From: Amanda Scholes on behalf of Planning.Responses
Sent: 02 June 2020 10:11
To: Planning Scanning
Subject: FW: Planning Consultation on M/28/20/DOC

APPLICATION NO: M/28/20/DOC

Site Address: Poultry Farm 87 Yapton Road Middleton-On-Sea PO22 6DY

Description of Works: Approval of details reserved by condition imposed under ref M/45/16/PL relating to Condition Nos 10 - foul water drainage, 11 - surface water drainage, 13 - discharge of flows to watercourses and 14 - SuDs

Site: YAPTON POULTRY FARM
Project: MIDDLETON RESIDENTIAL
Date: 01/07/2020
Drawing: SITE VISIT DISCUSSION
APPENDIX 02

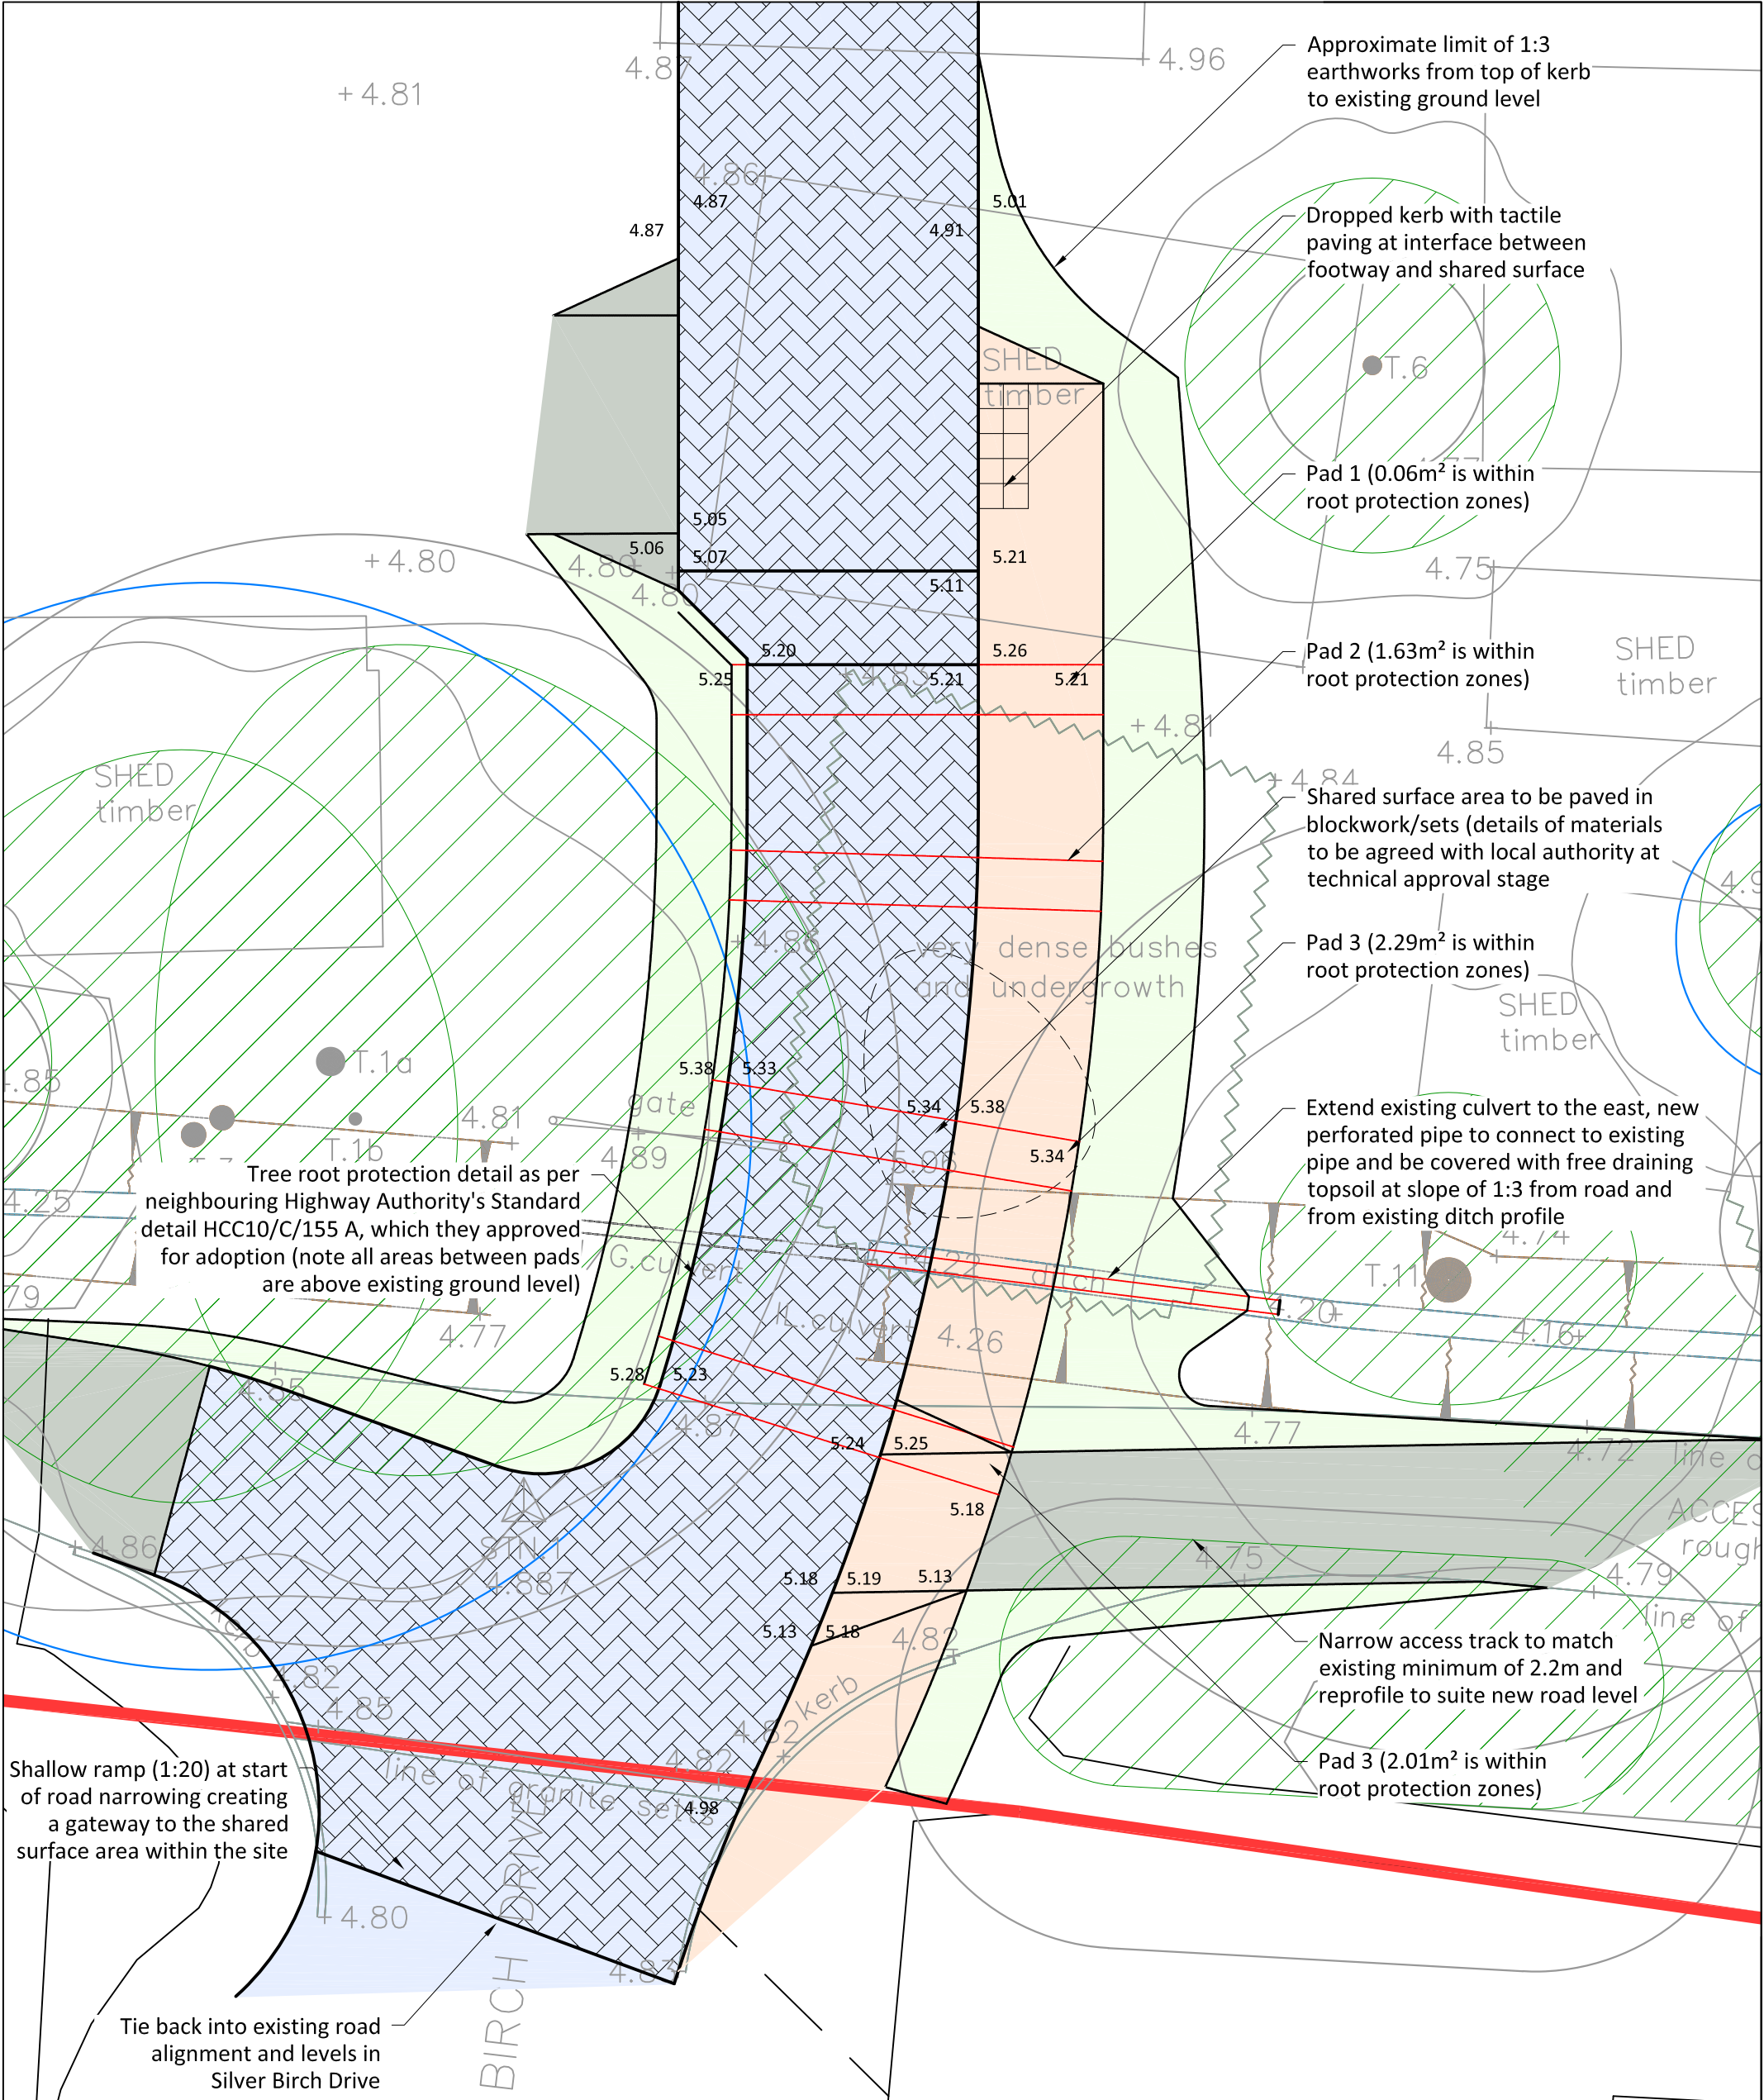
Regarding the ditches on the southern boundary, it is very likely that these will need improvements and I suggest a meeting takes place on site to look at these. Land Drainage Consent will be required for any alterations to them, including culverting and any discharge structures. This will all need to be fully detailed on the drawings.

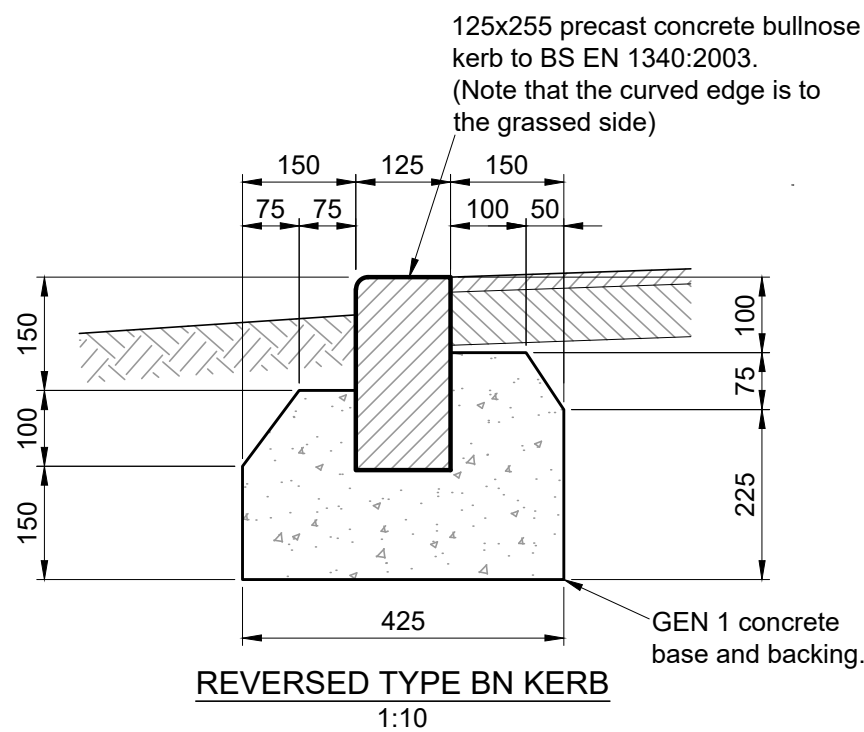
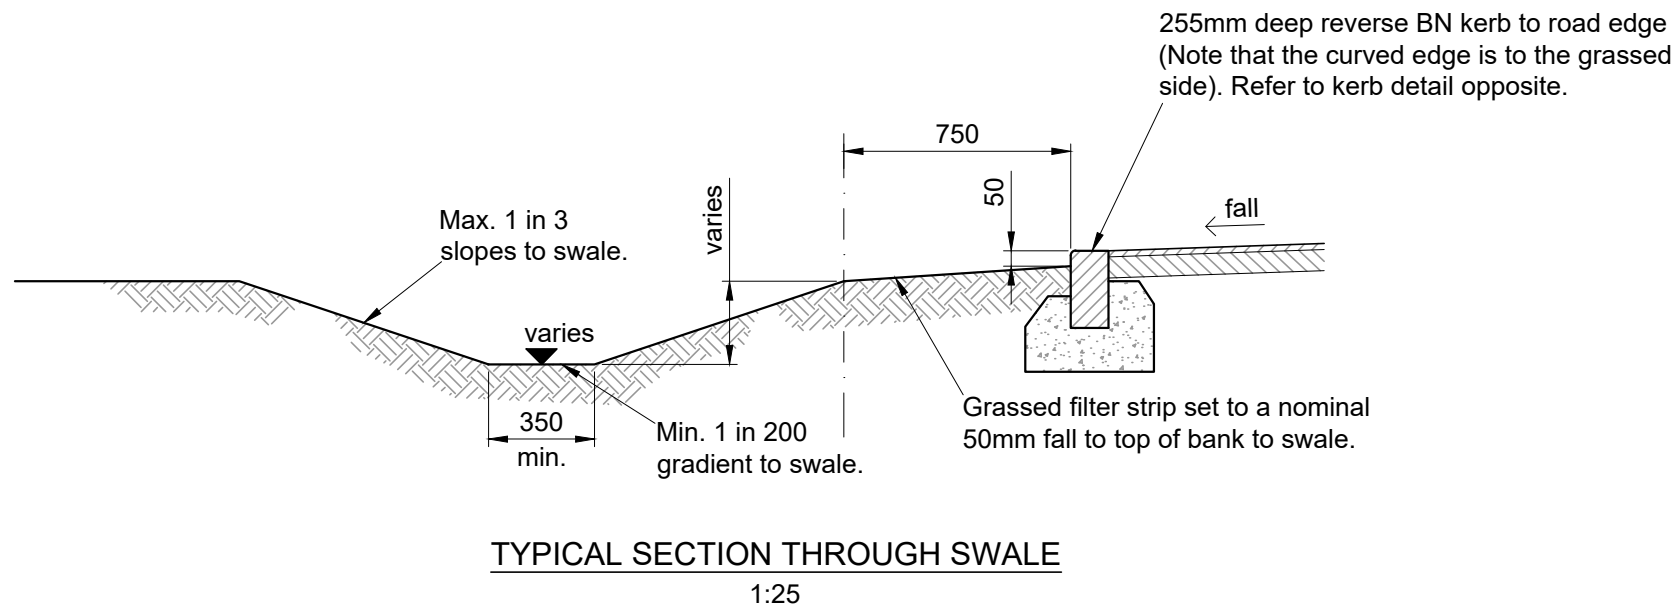
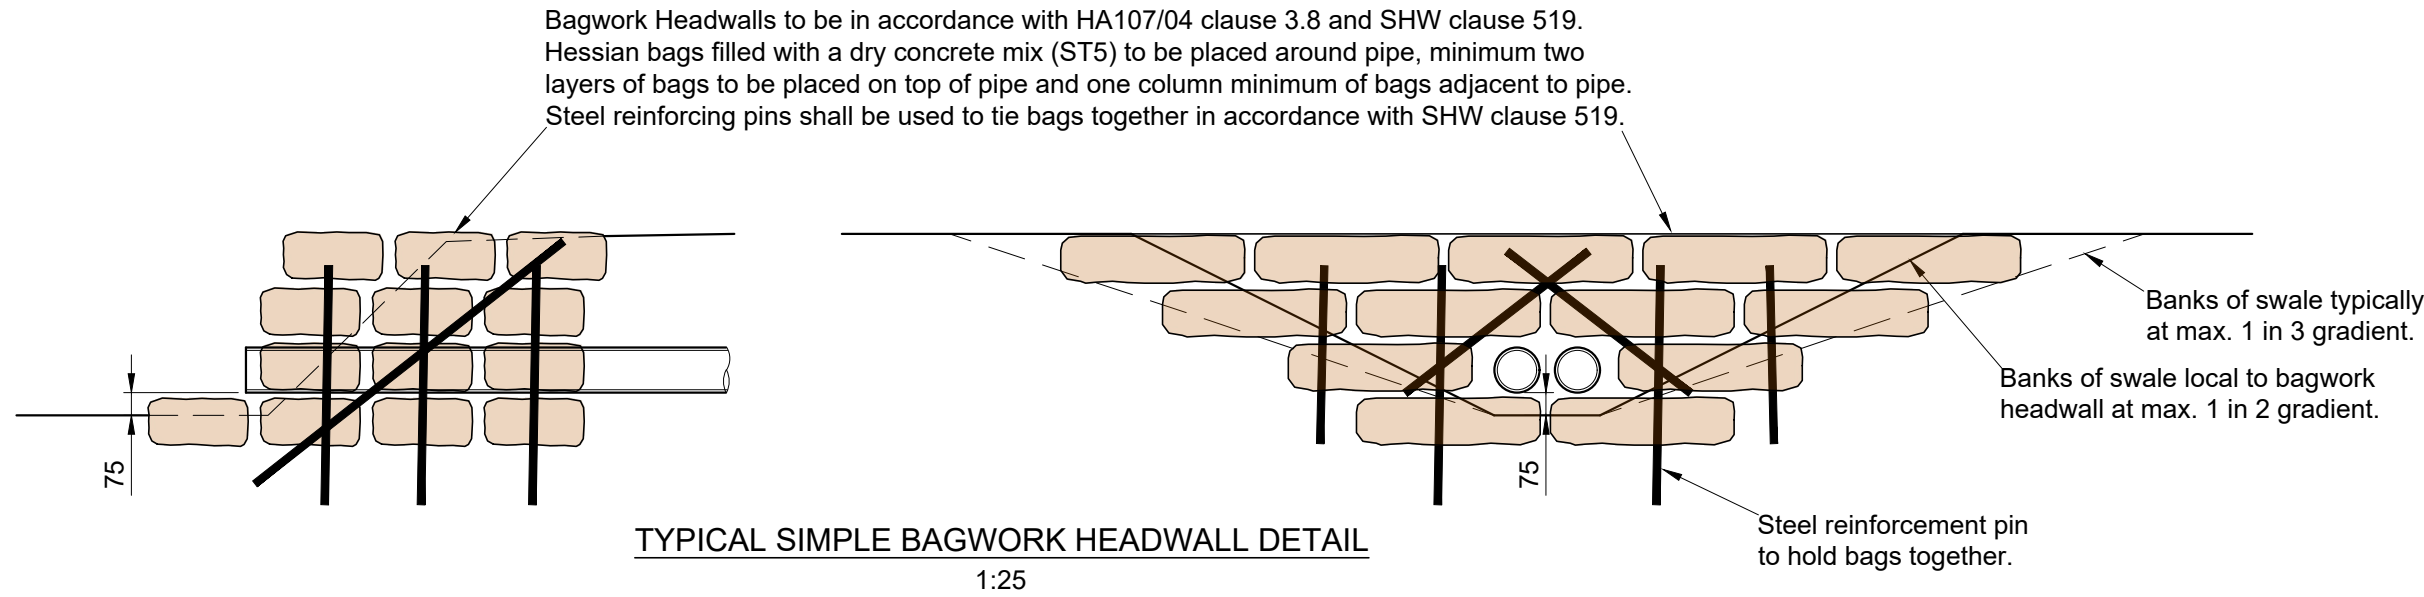
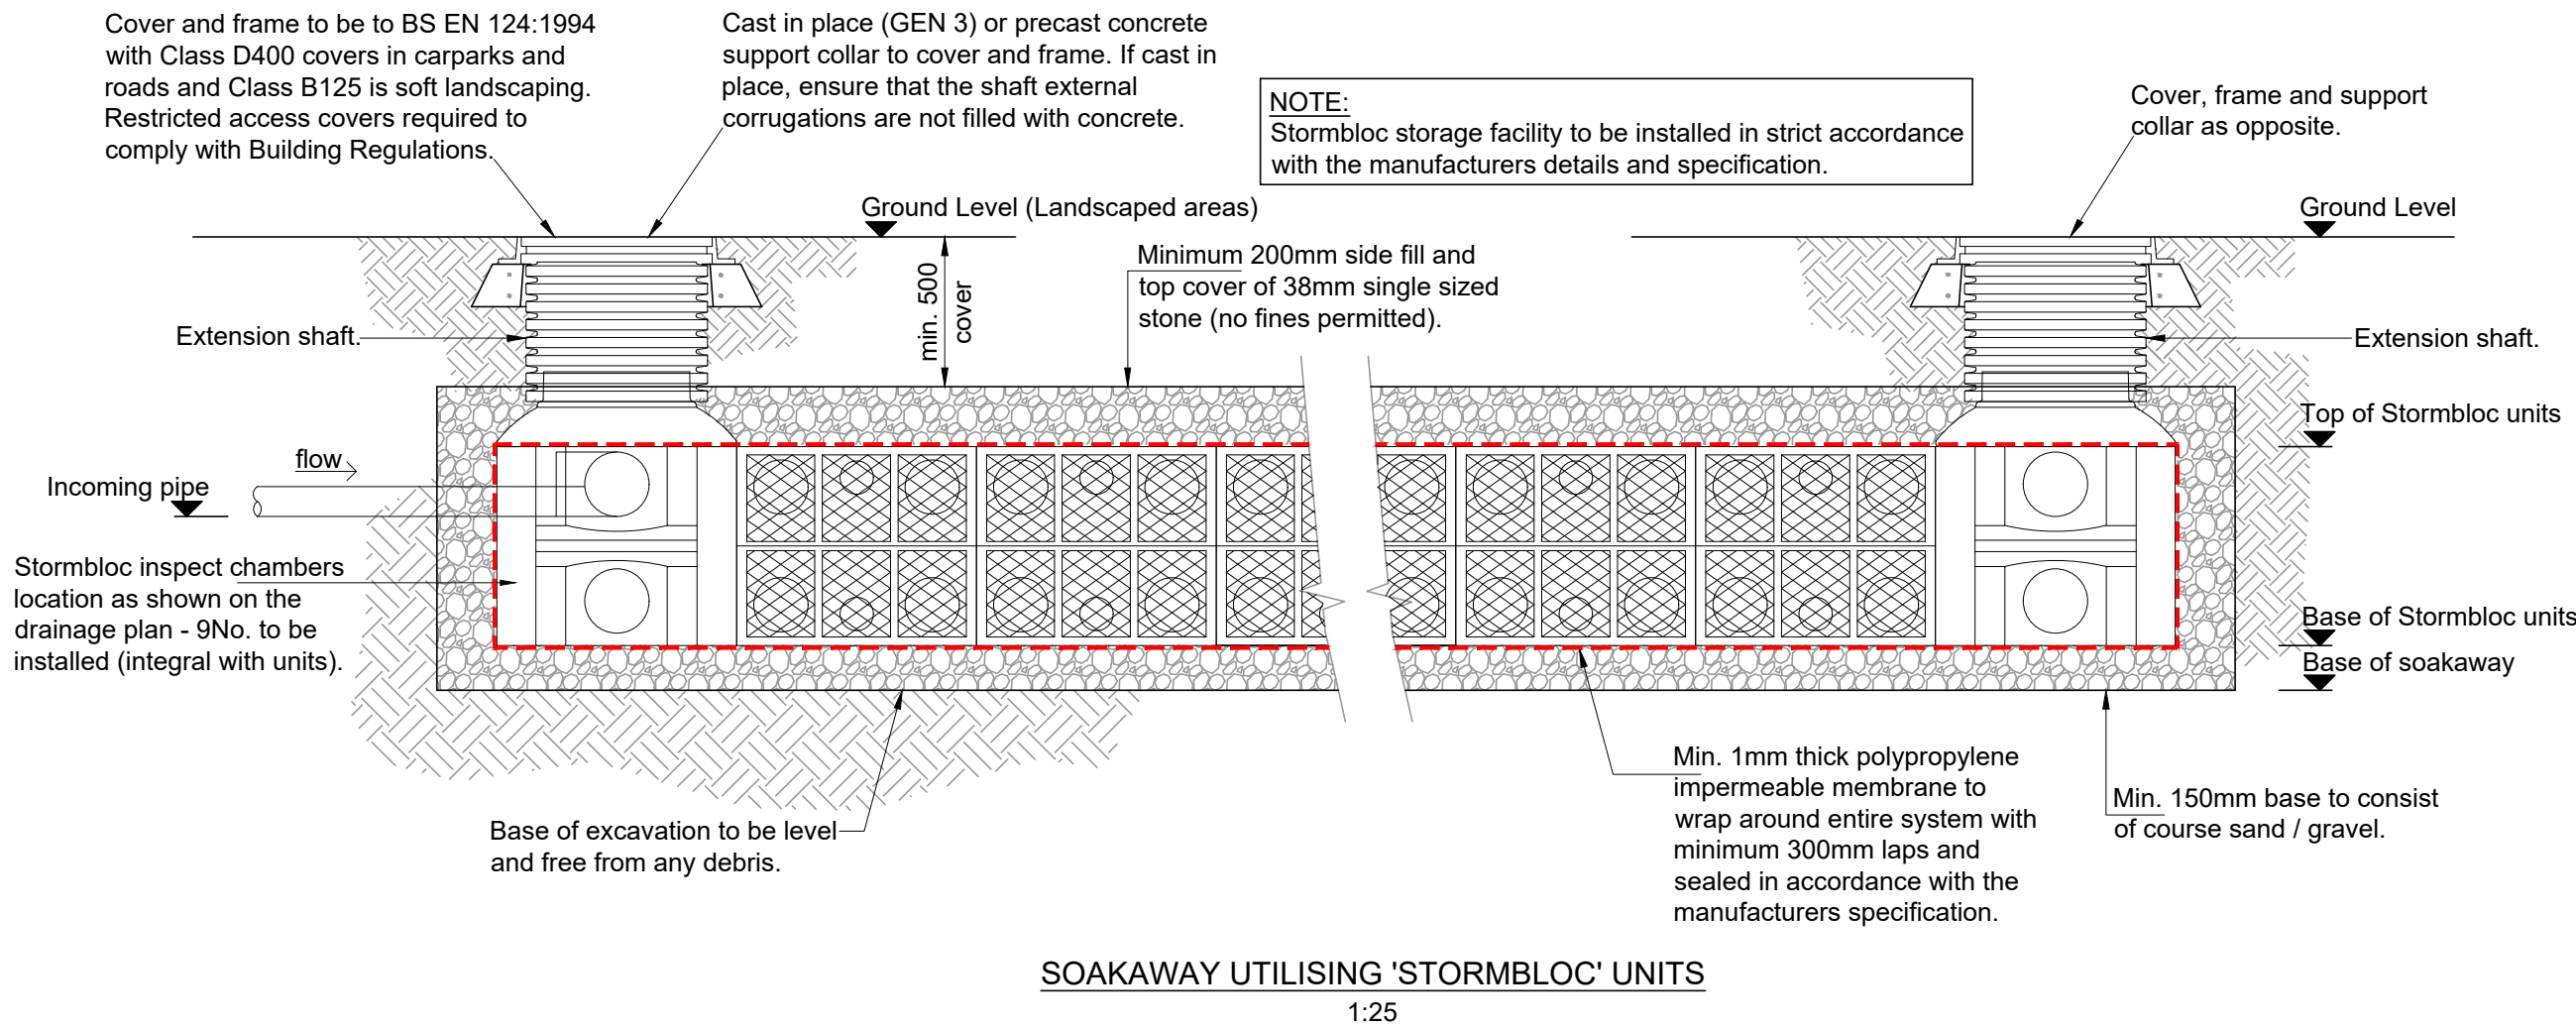
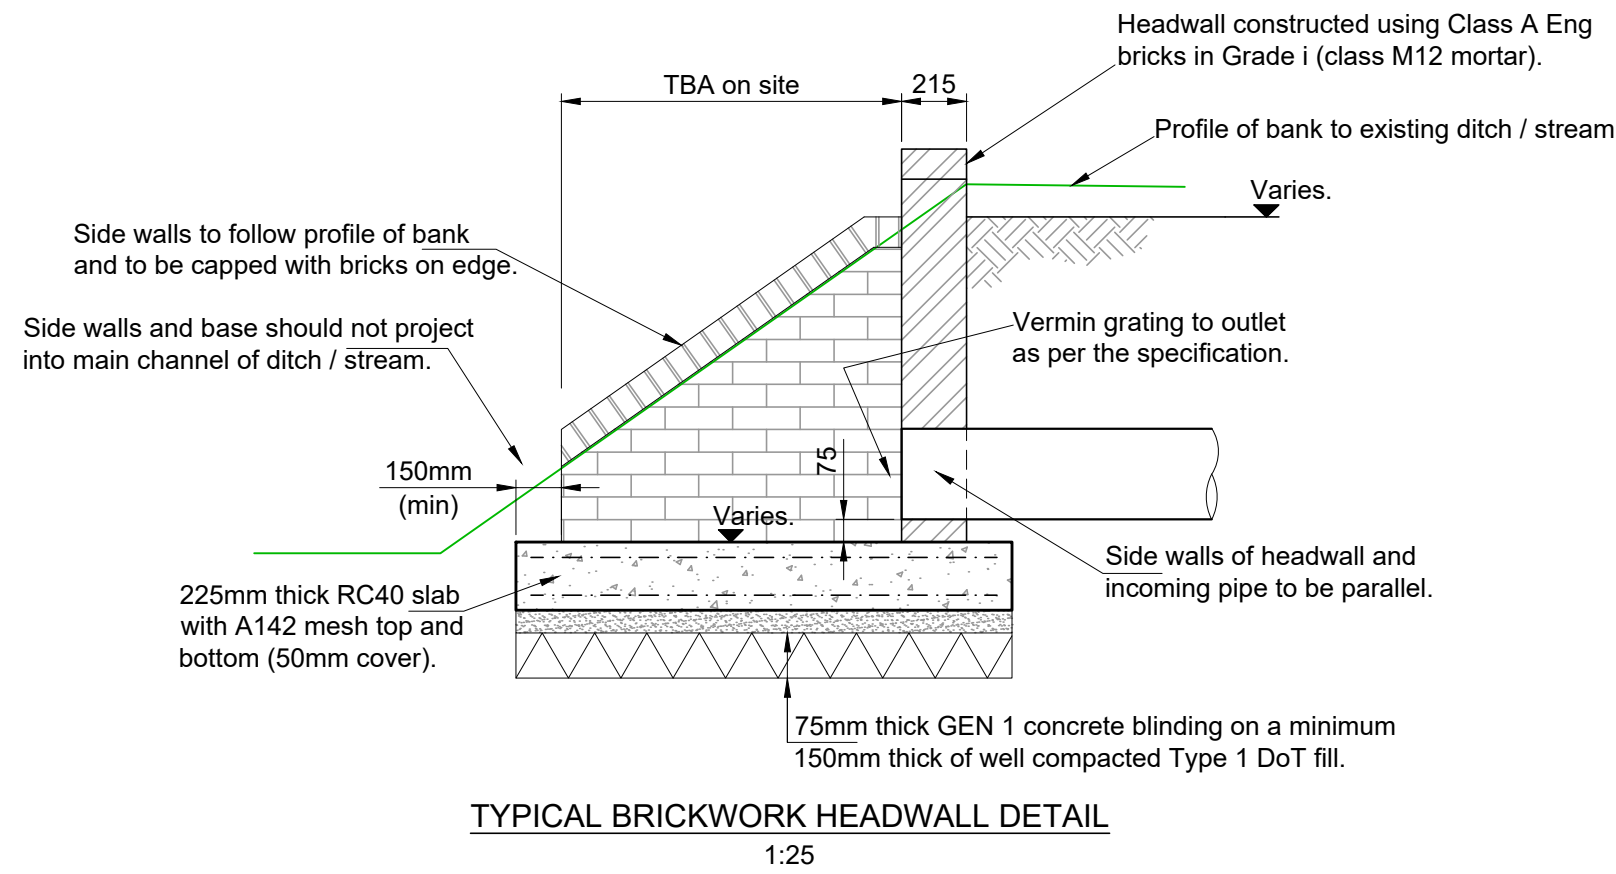
Once we have agreed the scheme principles, fully detailed plans will be required to include pipe/structure, cover levels/invert levels/base levels/diameters/gradients, etc, along with fully detailed construction drawings for all drainage elements. Please note that open suds features should be employed where possible. The current arrangement of crates is currently not desirable, since they have been arranged in manner as to use almost every piece of available space outside the root protection zones (zones will need to be confirmed), rather than achieve a more practical layout whereby membranes can be wrapped around the crates in a more suitable manner ie. reduce the number of corners. Please note that our tree officer will need to be involved in discussions in this respect due to protect the trees and the crates. Permeable paving will need to be employed where ever possible.
